1 March 2013

RE: Submission to MP09_0066 MOD 6 Thomas Street Carpark, Chatswood

Please consider this letter of objection to the above modification application.

1 GROUND FLOOR PLAN  
1:200

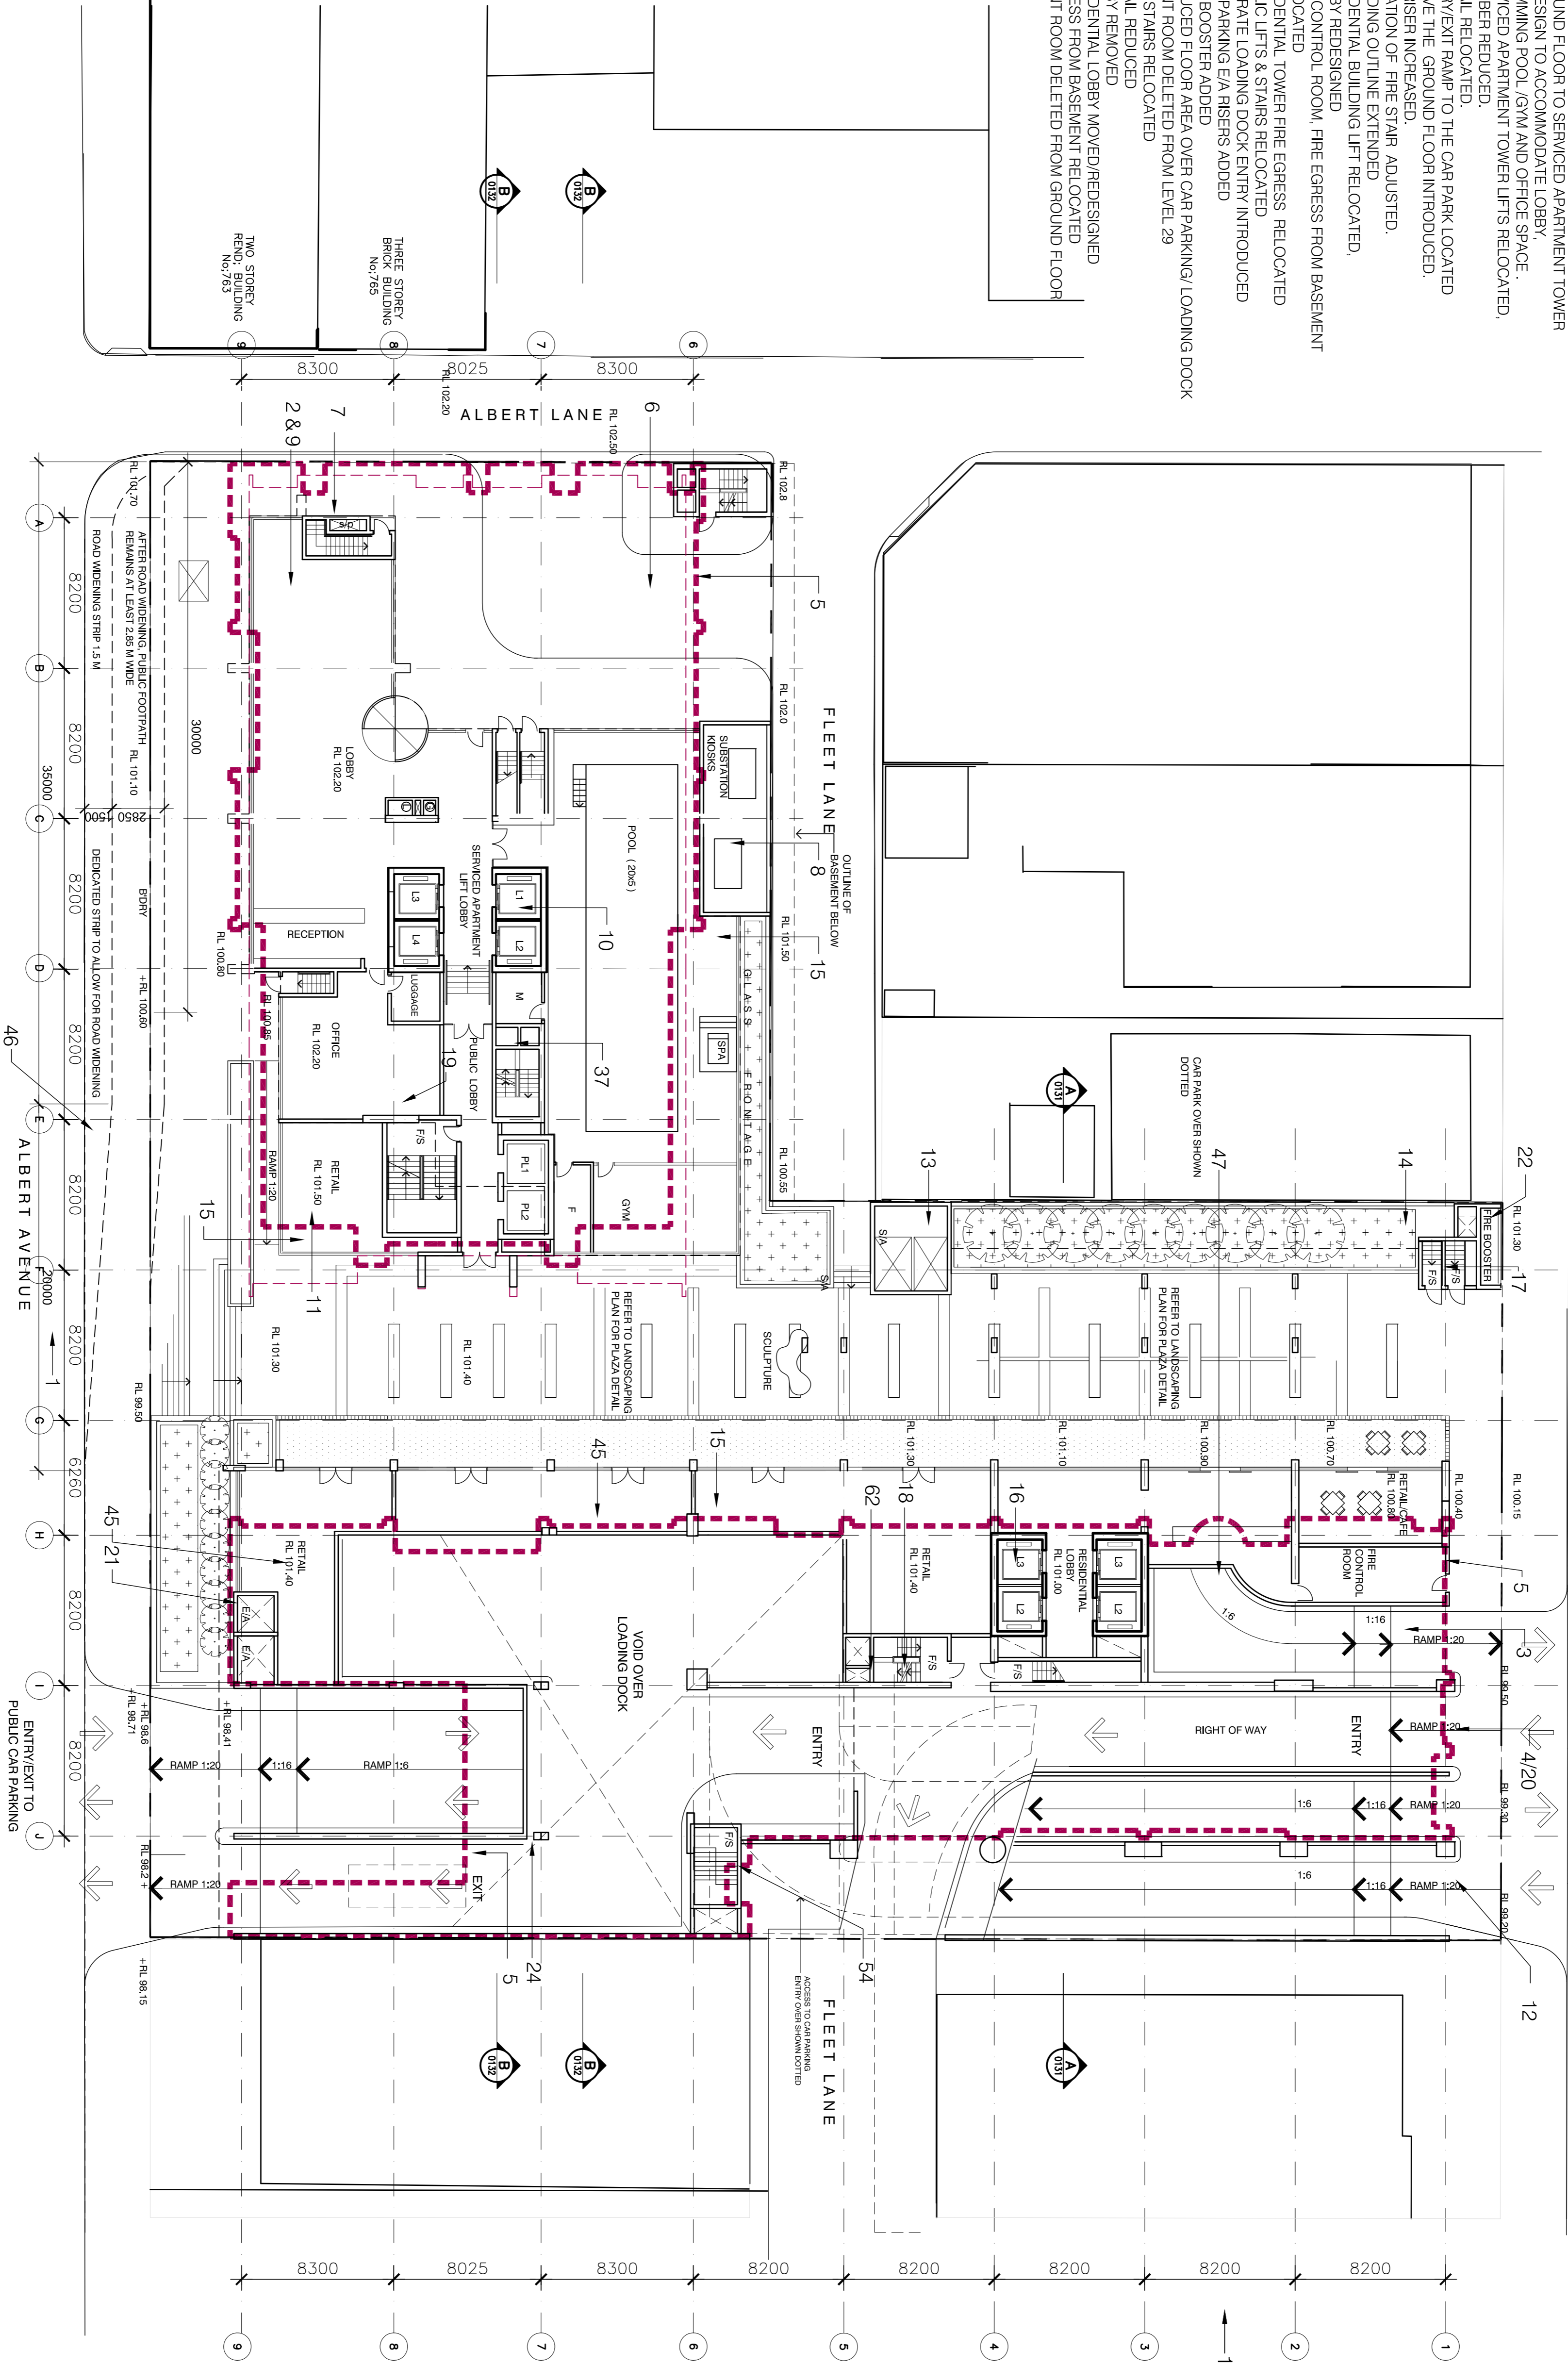
It is of great concern to me that pedestrian and disabled access via the ROW to the disability ramp of 12 Thomas Street is not addressed in the plans. This raises concerns of safety and ease of access to 12 Thomas Street. For example: a protected/designated walk path, lighting and maintenance of the ROW to ensure no debris is obstructing the path.

Although there will be public car park spaces in the Residential Tower it is not clear that the designated disabled spaces will have ease of access to Thomas Street. There are no details that I can find as to how a disabled, injured or elderly person access Thomas Street safely and efficiently. Also, now that there are 2 exits onto Thomas Street this increases the risk and danger of traffic to pedestrians.

1 ELEVATION – SOUTH
1:250

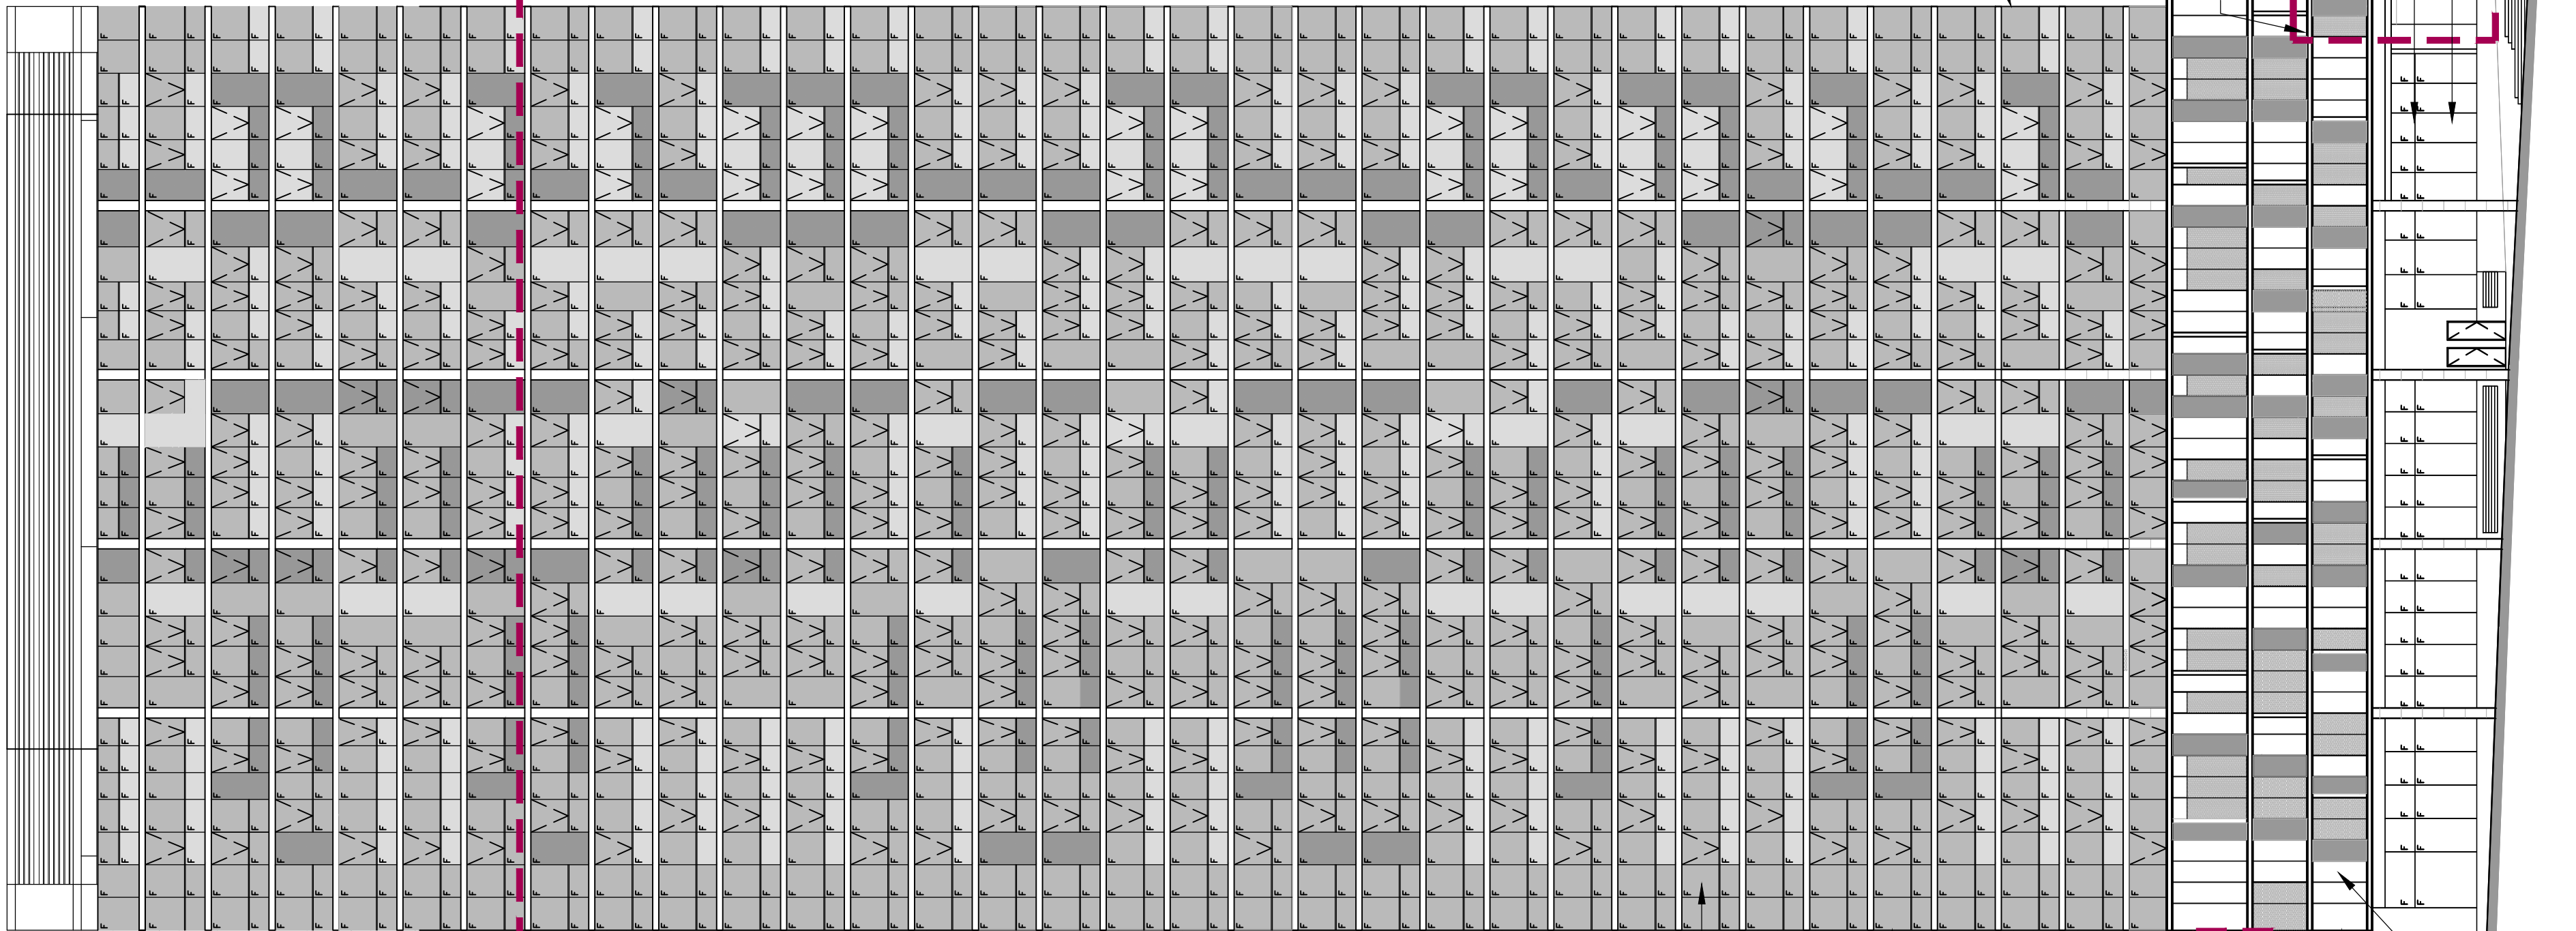
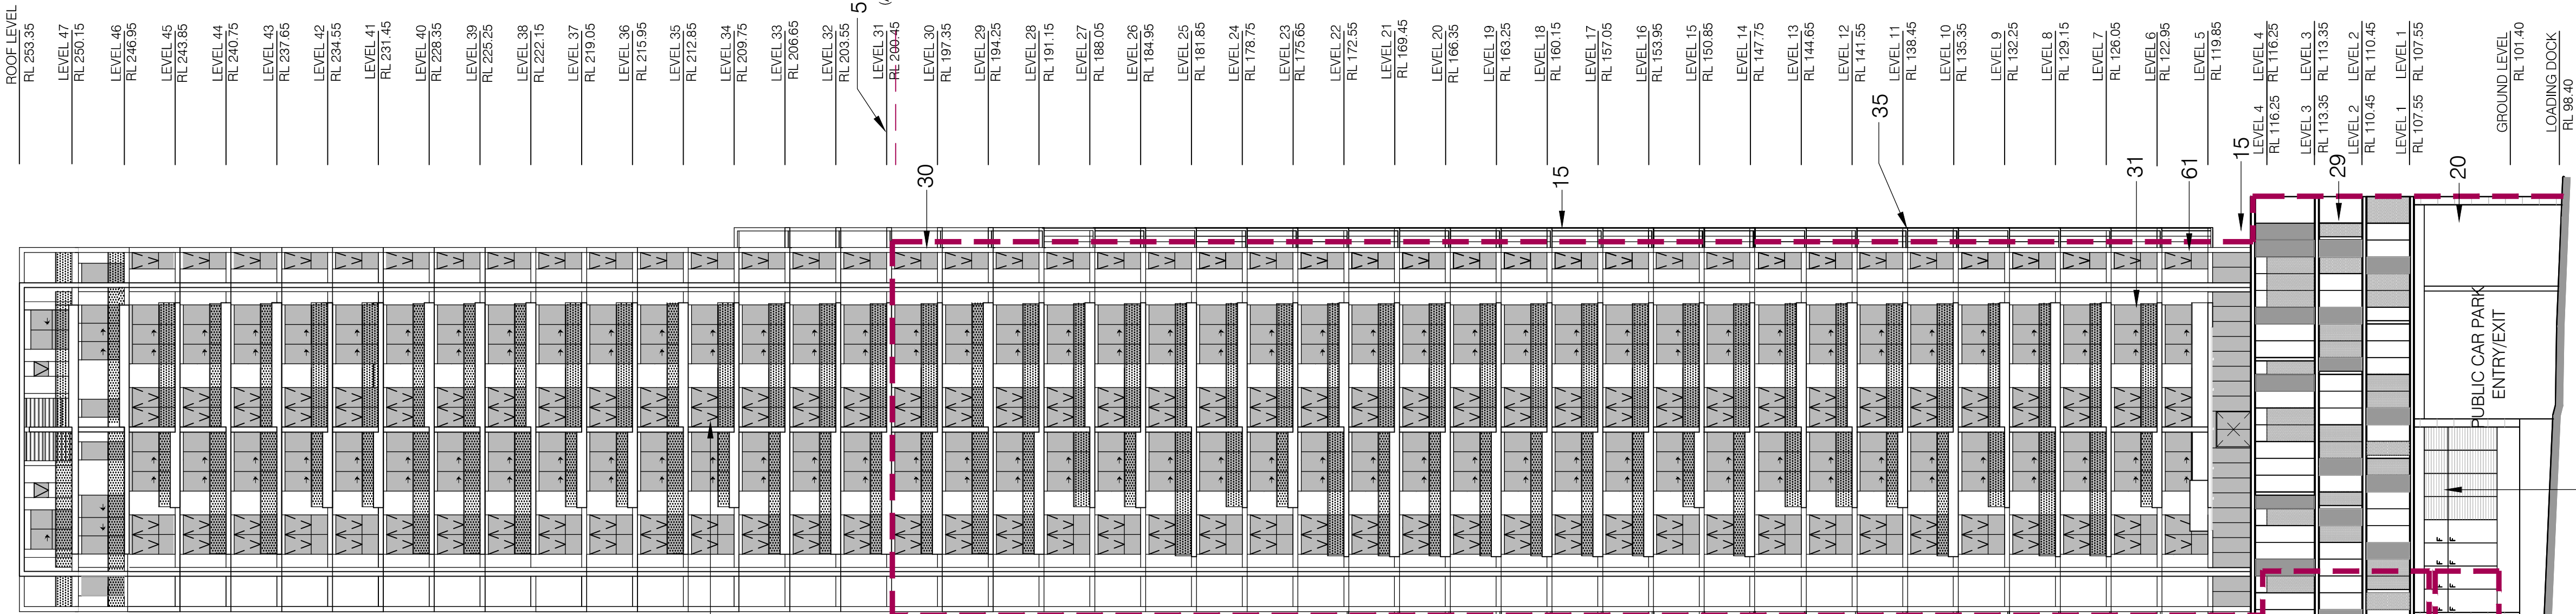
I object to the proposed height increase, as it will adversely affect amenity. Lack of sunlight and the overbearing stature the building is objectionable. I currently have a large outlook to the west and enjoy the sunsets. With the new tower I will lose this view and will be imposed on by this overbearing tower.

I strongly object to the proposed modification to lower the height of the cantilevered floors of the Meriton Residential Tower over the ROW – as it is the Meriton Building will dwarf 12 Thomas Street and will adversely affect natural sunlight , my view . The building will be a monstrosity with a claustrophobic presence. It is my understanding that the cantilever over the ROW has been approved to start at approximately the height of level 4 or 5 of 12 Thomas Street which will allow for some respite (distance) from the residential tower if
